From: Al Juvera <ajuvera@csu.org>
Sent: Wednesday, October 19, 2022 10:04 AM
To: Daniel Feuerbach
Subject: 1st review 9040 Chipita Park Rd - Temp Carport BOA2214

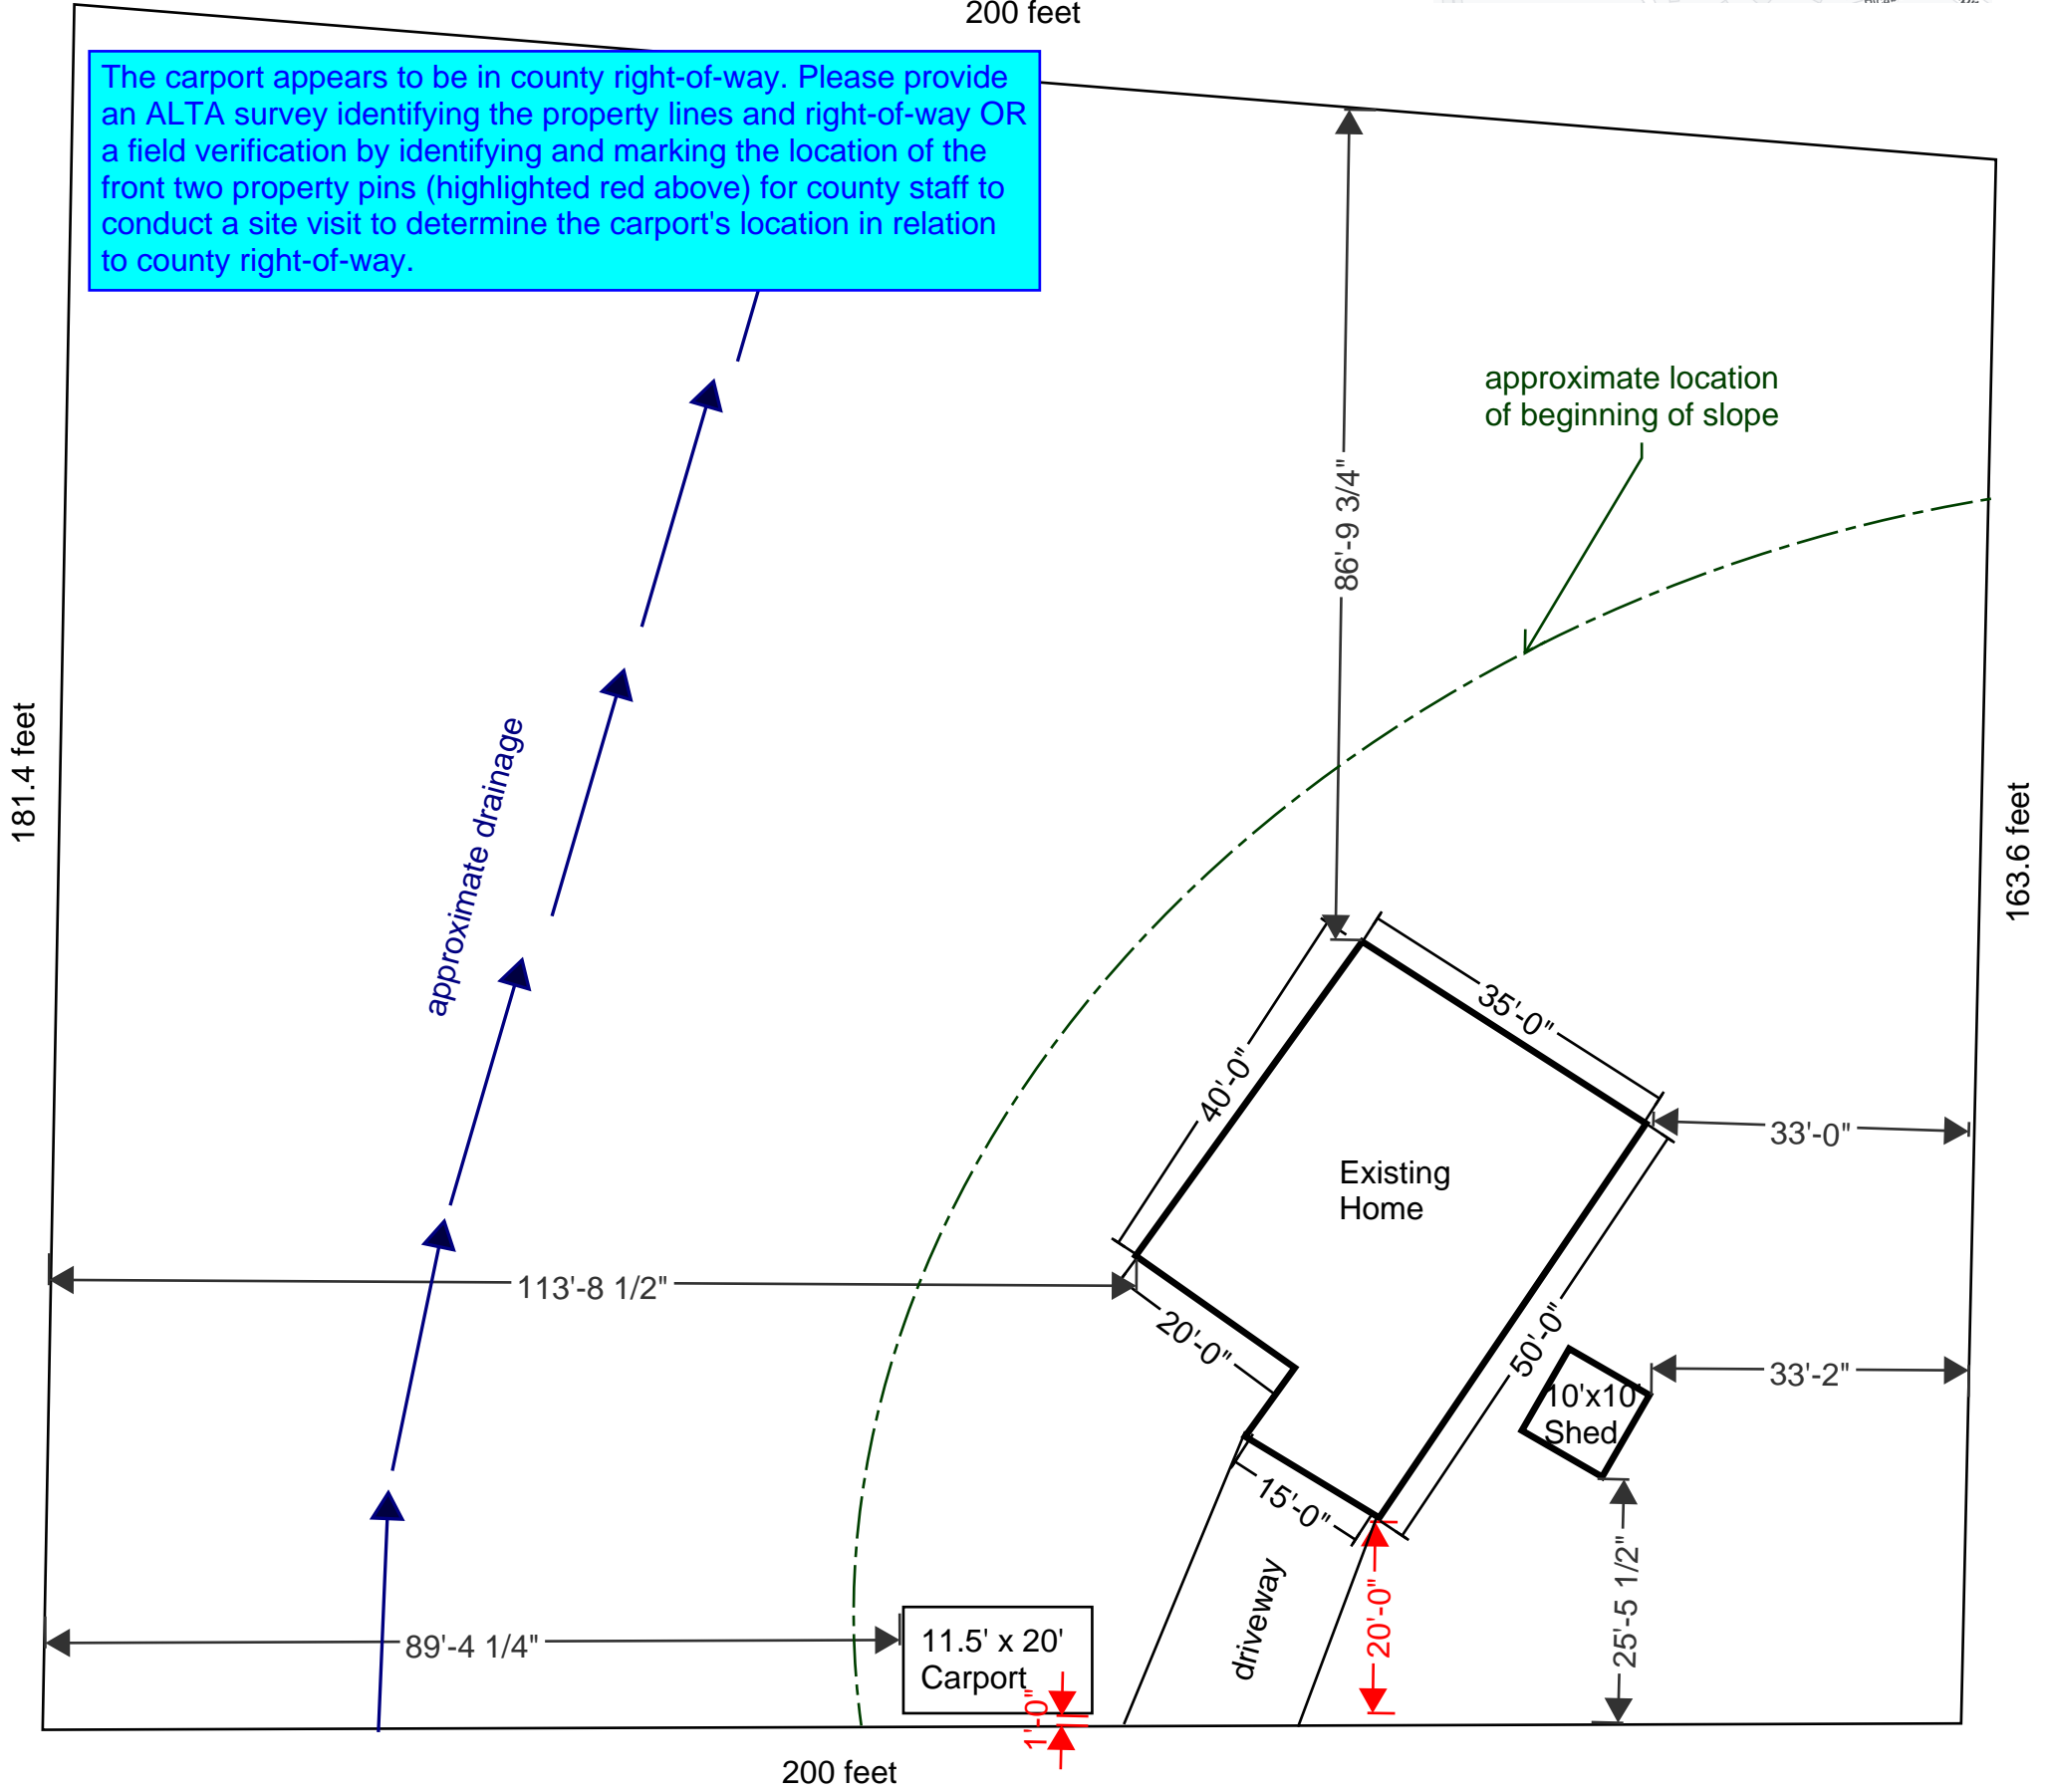
Dan, there is an existing water main that runs through the lot the water main will need to be located and shown on the drawing along with the existing easement size and reception number. However if an easement does not exist then an easement will need to be granted prior to plan approval.
